**WEST SUSSEX COUNTY COUNCIL
INFRASTRUCTURE CONSULTATION**

SUBJECT: CM/14/10/DOC- Application for approval of details reserved by condition 4, 5 and 7 following the granting planning permission CM/13/07.

Field Place, Church Lane, Climping, West Sussex, BN17 5RR

Drawing number:
2428-05

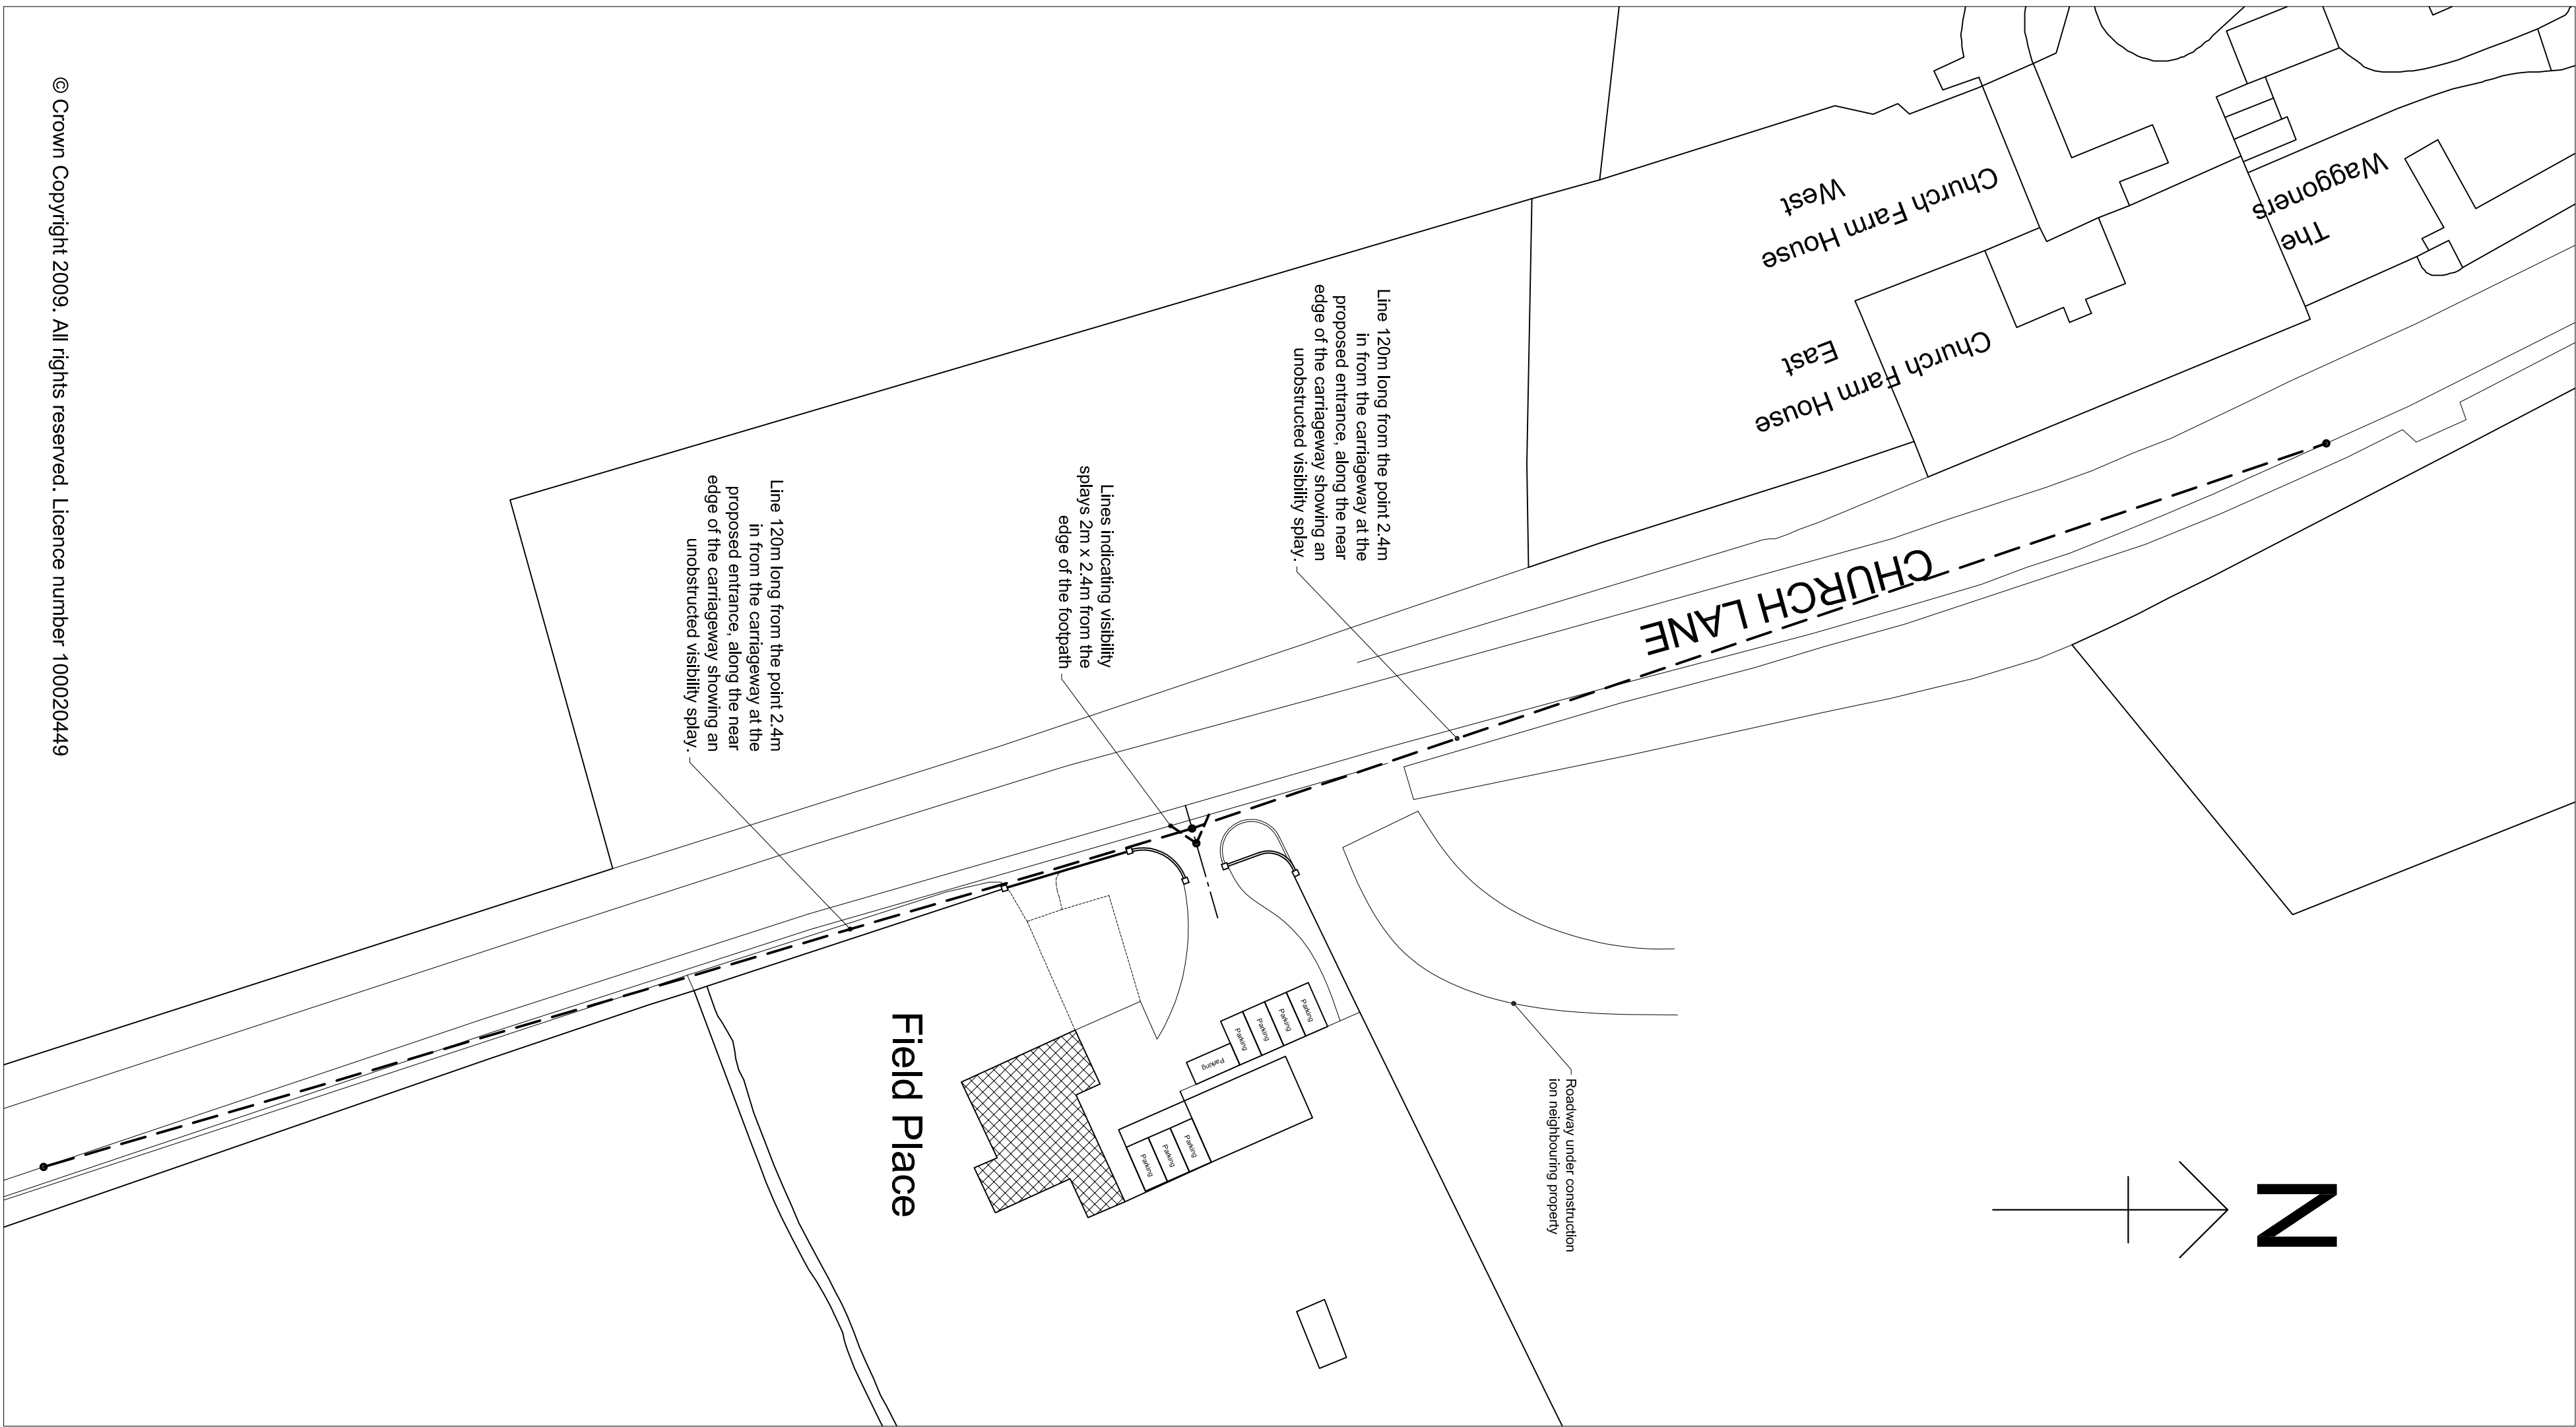
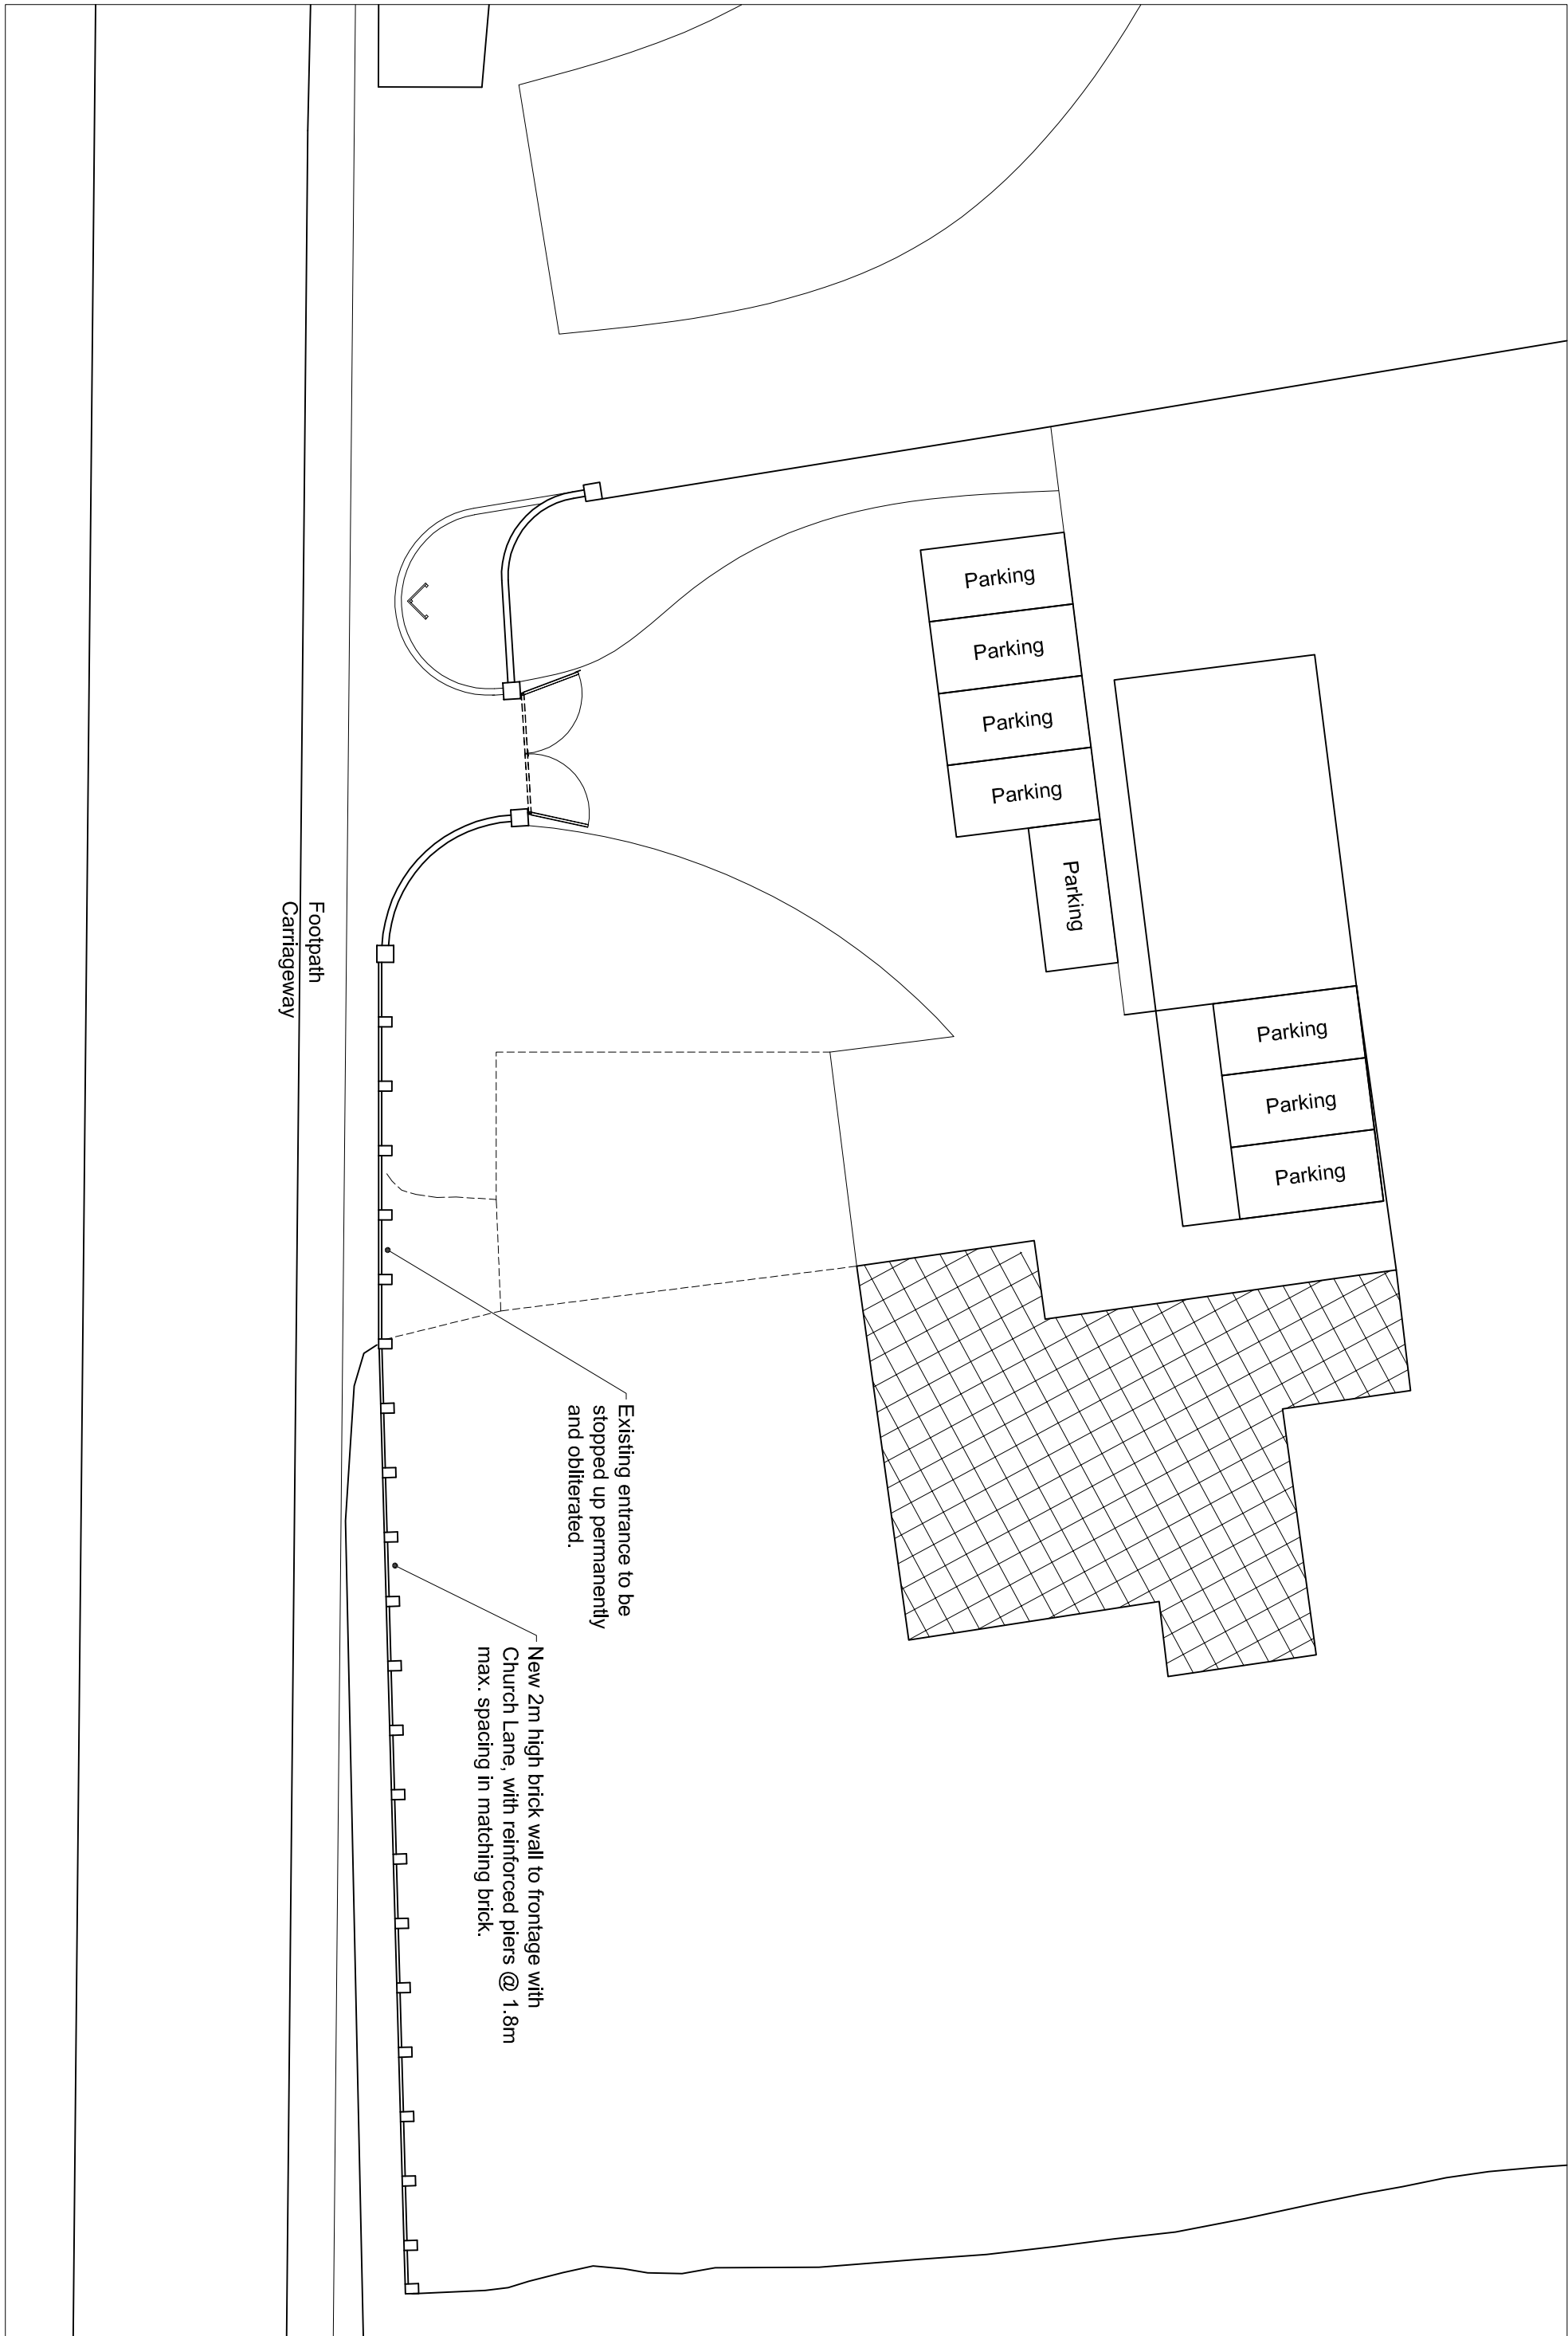
The proposal and its particular are described above. Looking at ADC's website there do not appear to be any plans that show the requested visibility splays (of 2.4 by 120 metres), new access and gates and pillars shown at the point of access. I would appreciate if these details were shown on a scale 1:500 plan.
